Our Ref: R/2016/1/C
File No: MP 08_0098 MOD 13

Modification Request for The Star (MP08_0098 MOD 13) – 20-80 Pyrmont Street, Pyrmont

The City of Sydney (the City) has reviewed the information provided as part of the public exhibition and **objects** to the Section 75W modification of the project approval.

For Information

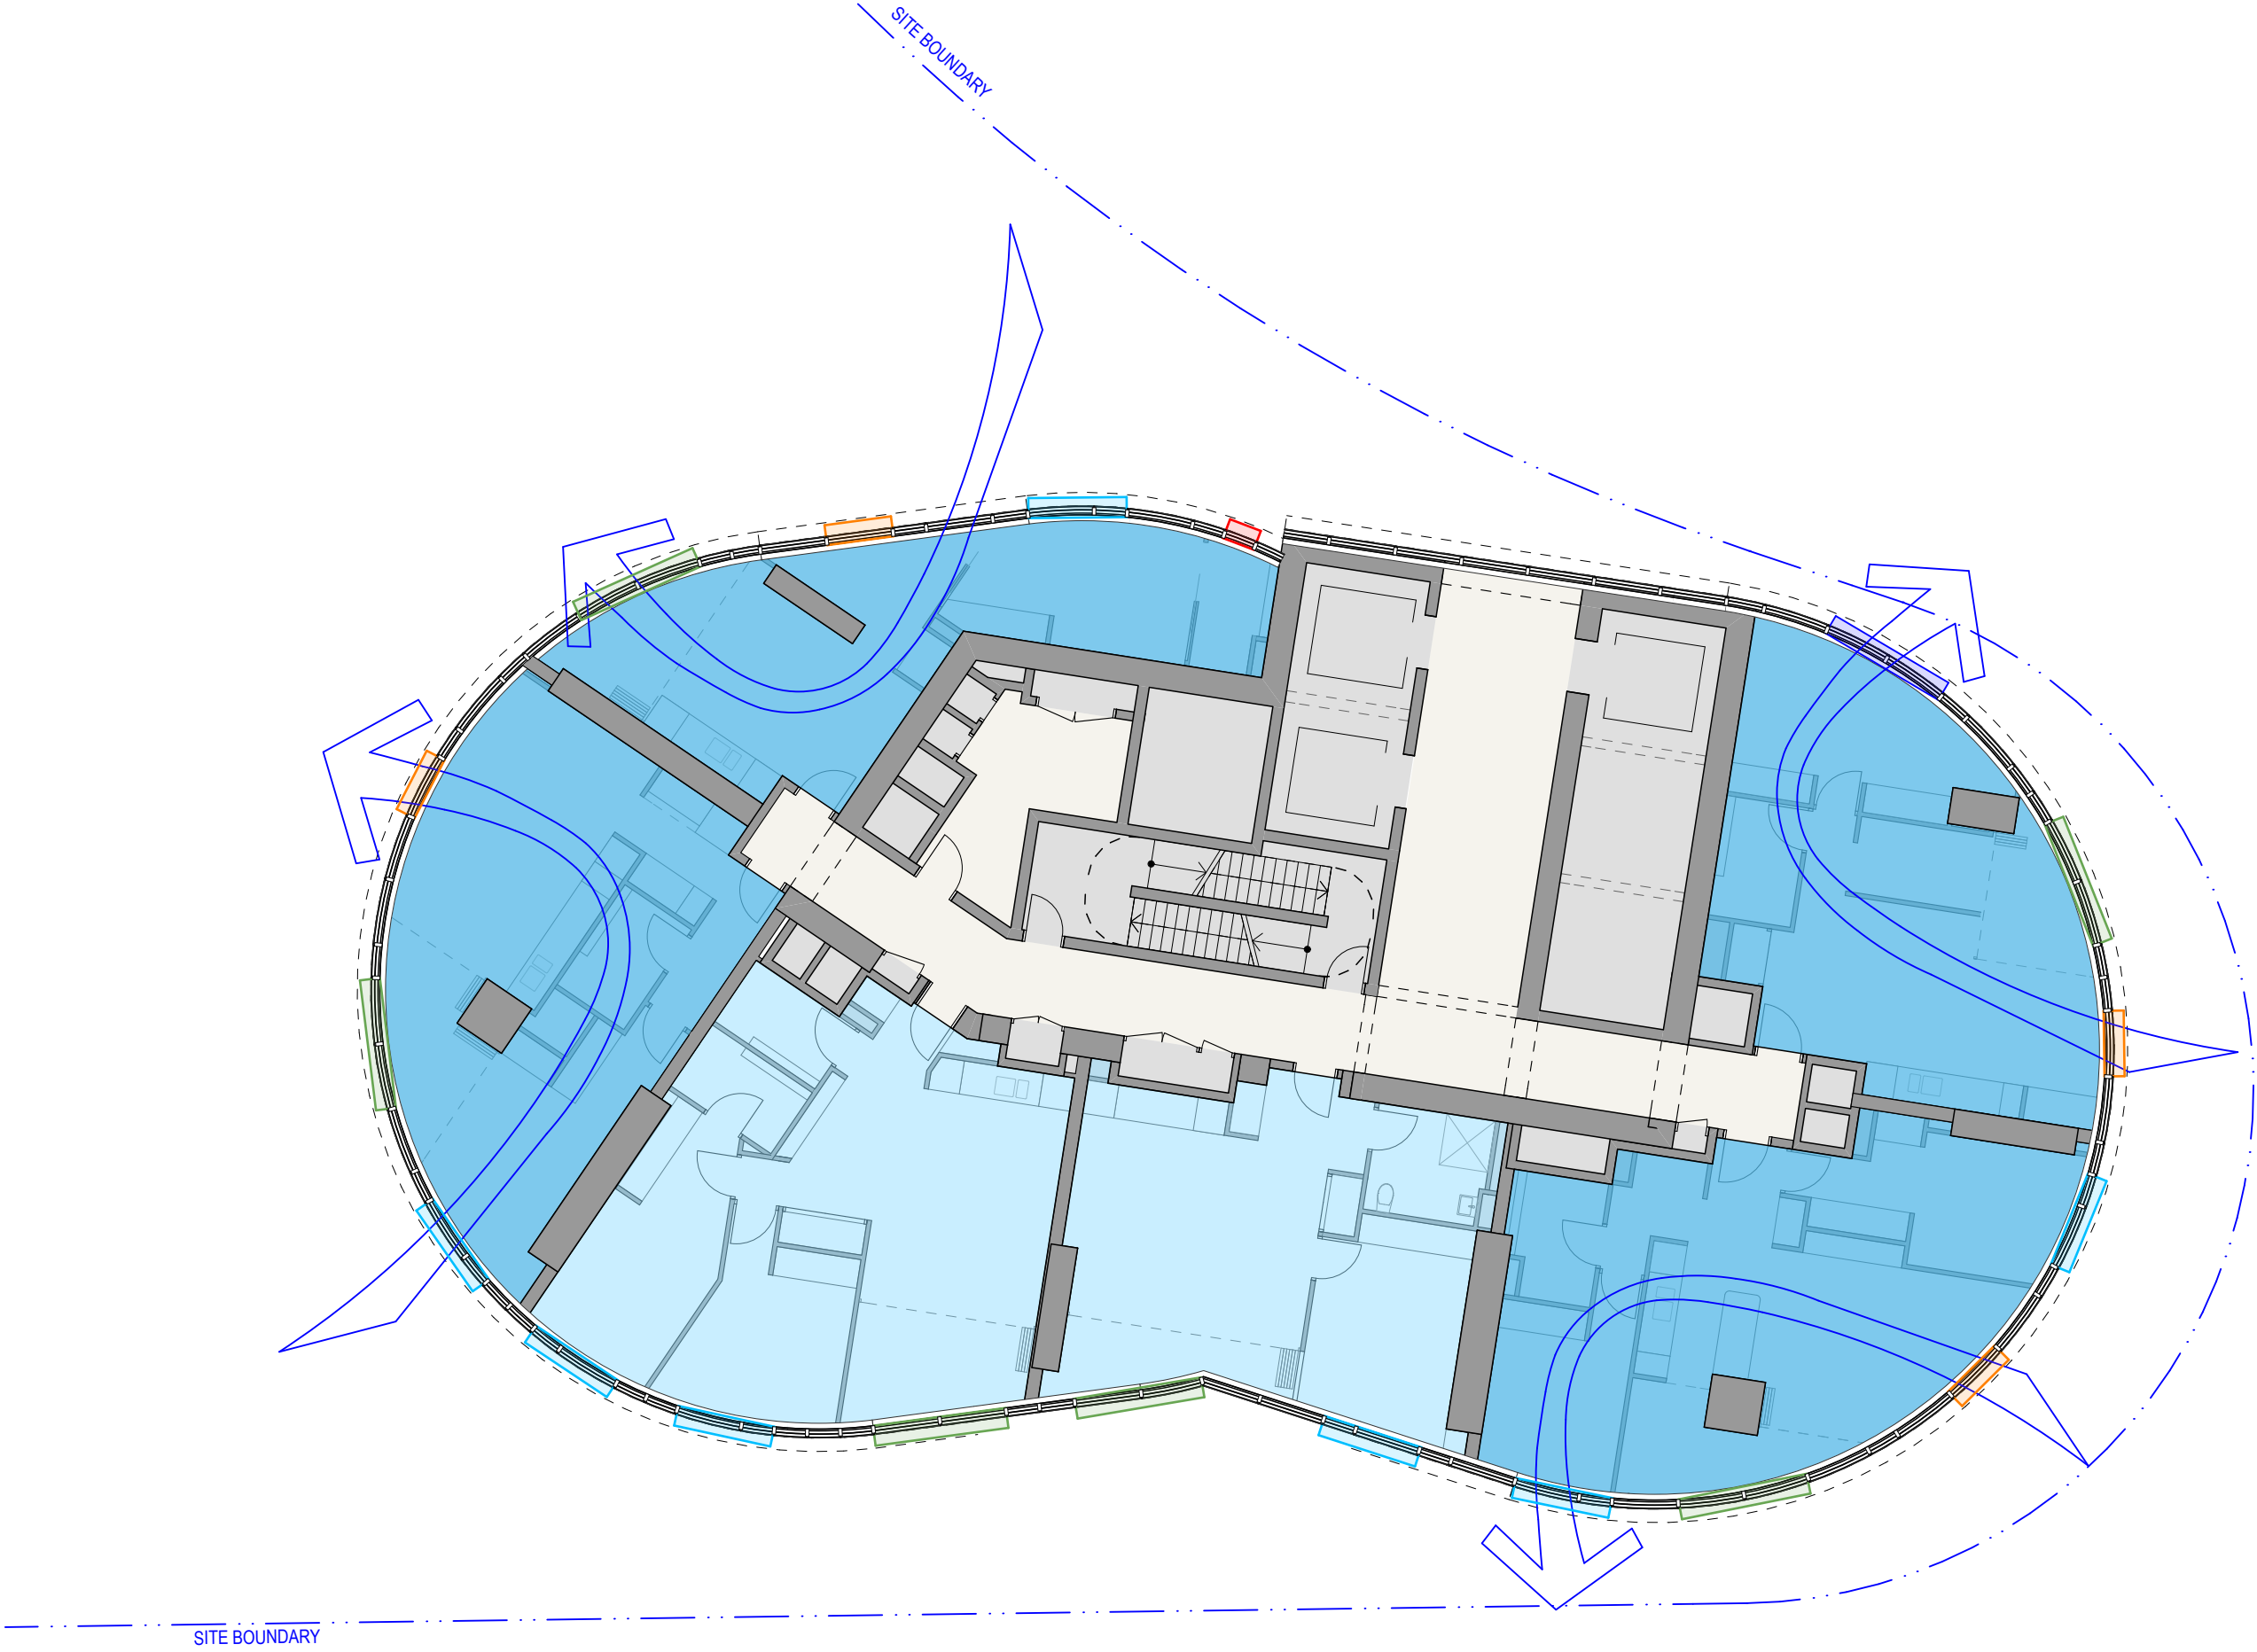
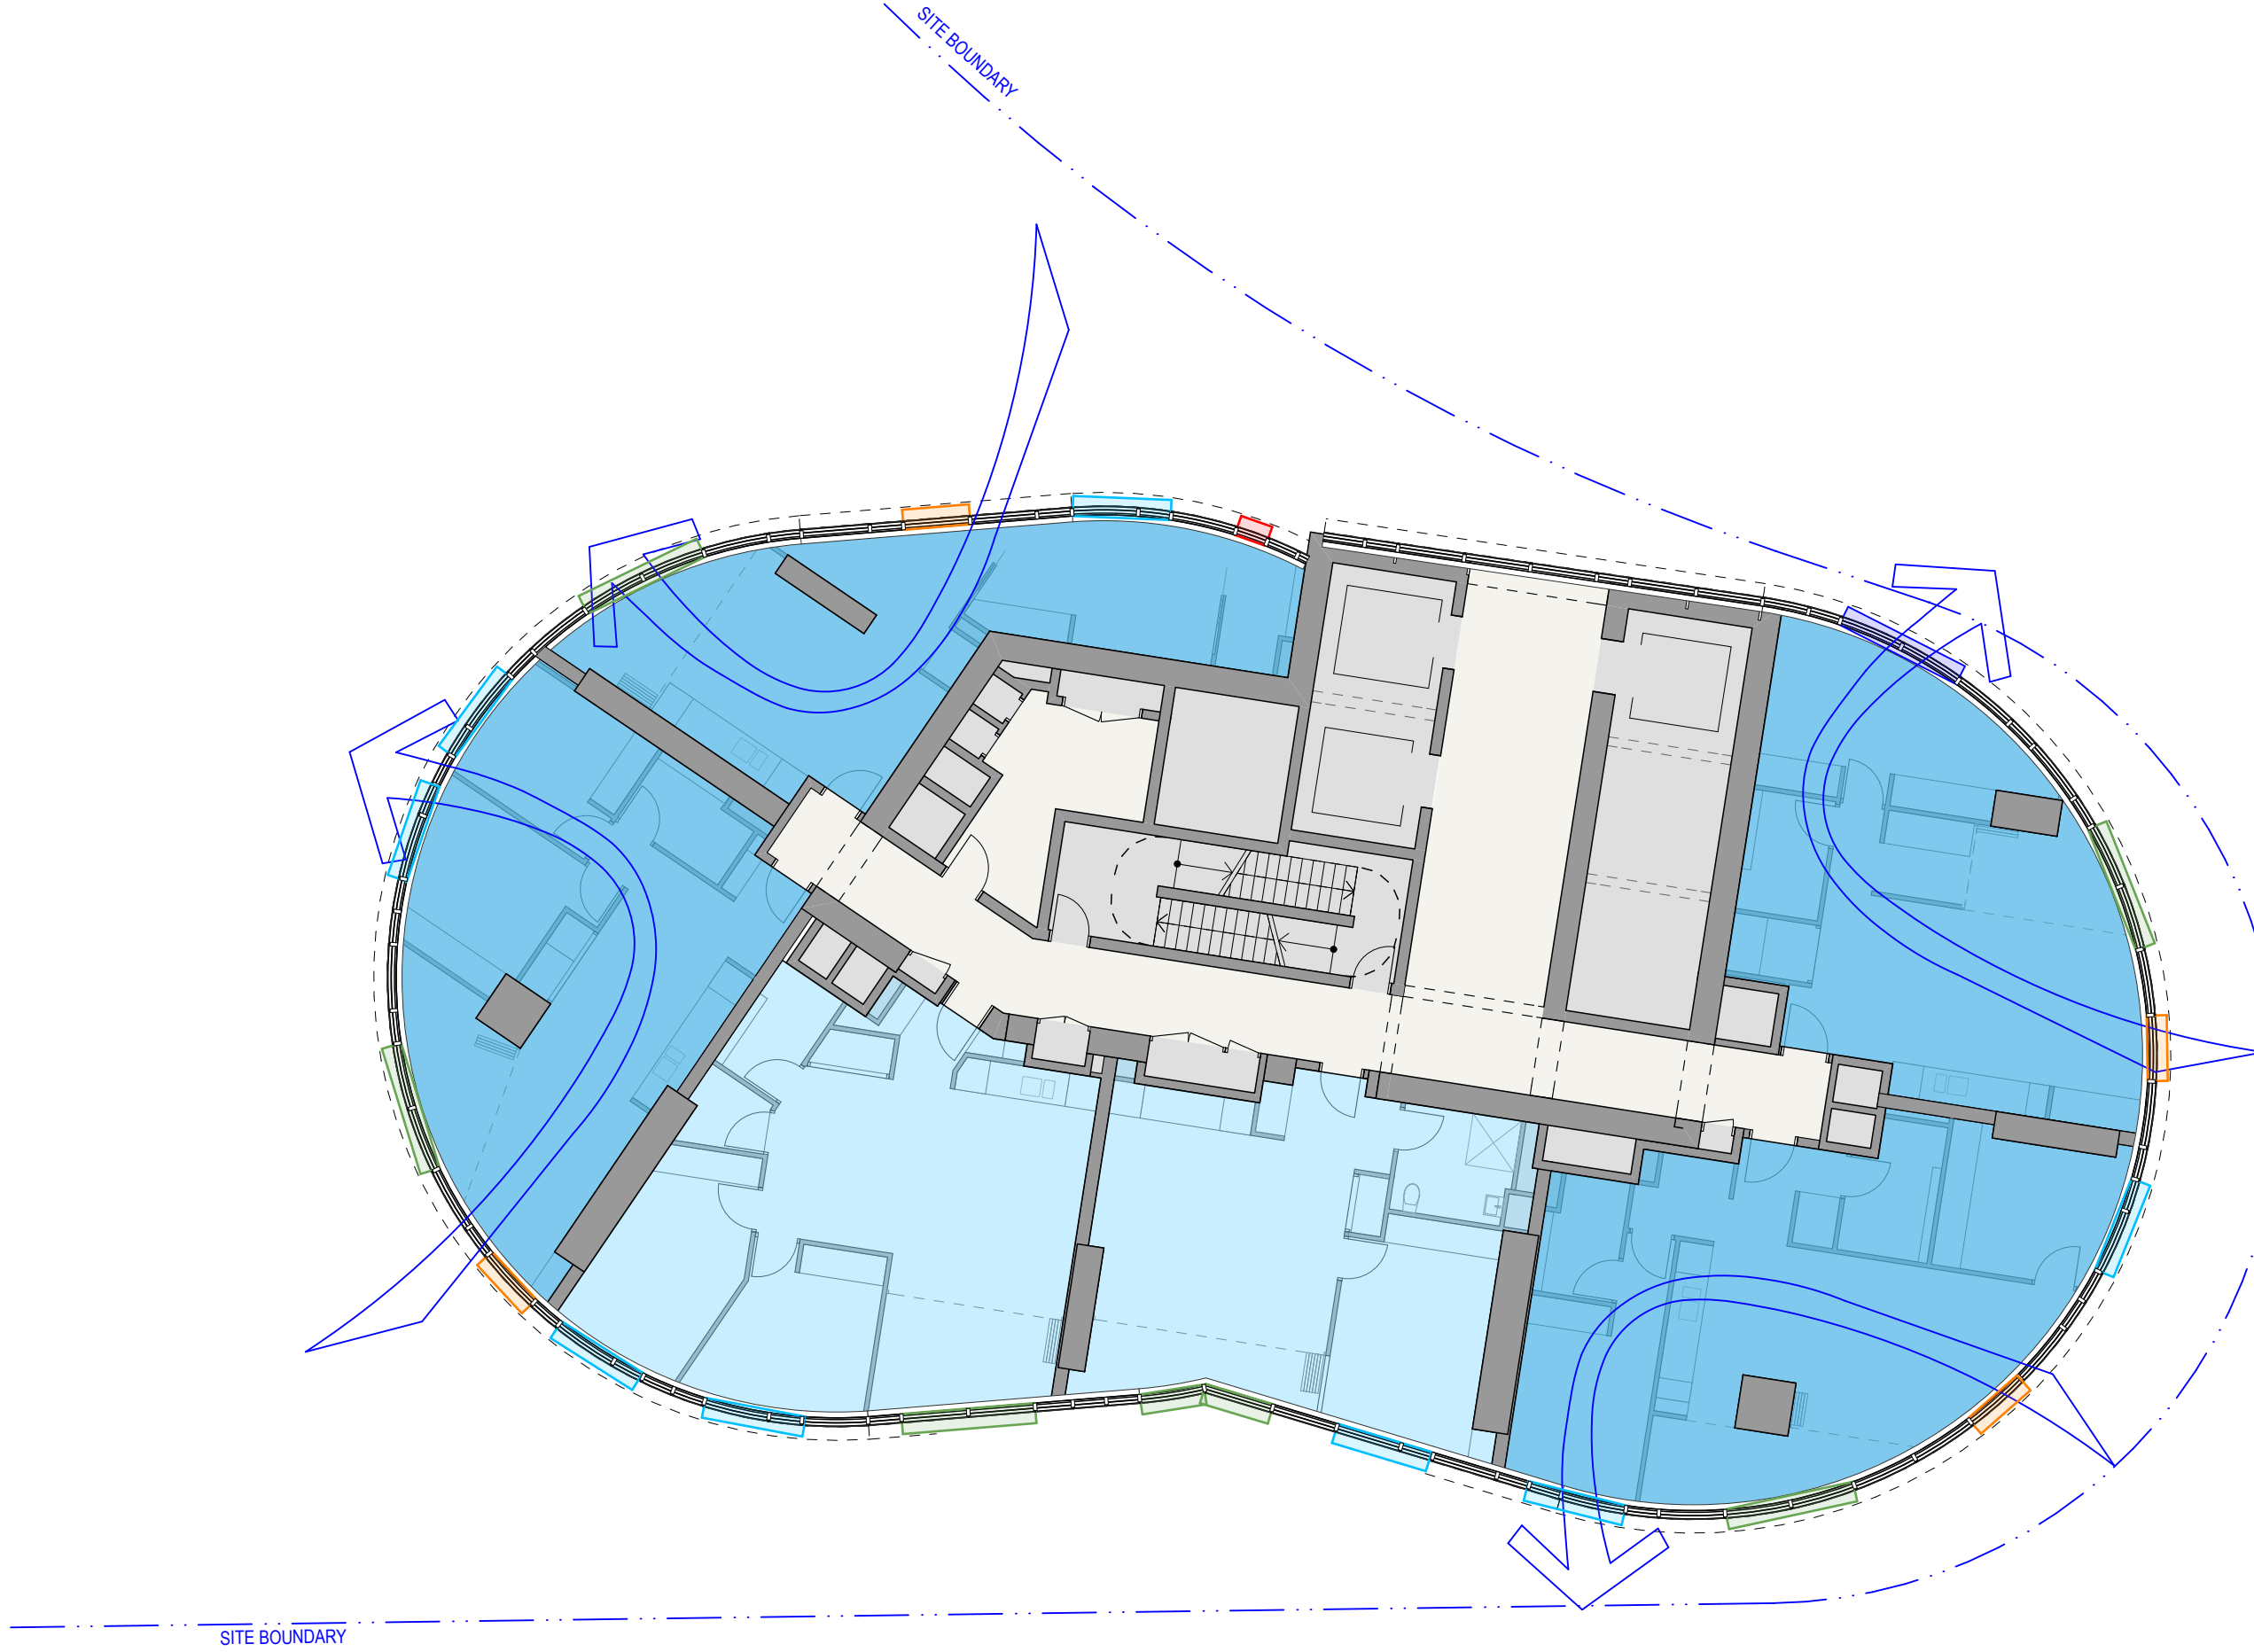
- Inadequate detail has been provided to establish how the natural ventilation requirements of the ADG will be met. The architectural plans do not show *any* operable windows to apartments. All glazing, including to wintergardens, is drawn in plan to appear as a curtain wall. This provides an unacceptable level of amenity.

- The Noise Impact Assessment states that all residential windows will need to remain closed with mechanical ventilation relied upon to meet required internal noise levels. This solution does not comply with Objective 4B-1 in the ADG requiring all habitable rooms to be naturally ventilated.

- 70% of apartments located below level 10 of the building are to be naturally cross ventilated. Due to the apparent curtain wall sealing all windows, no apartments appear to be naturally cross ventilated.
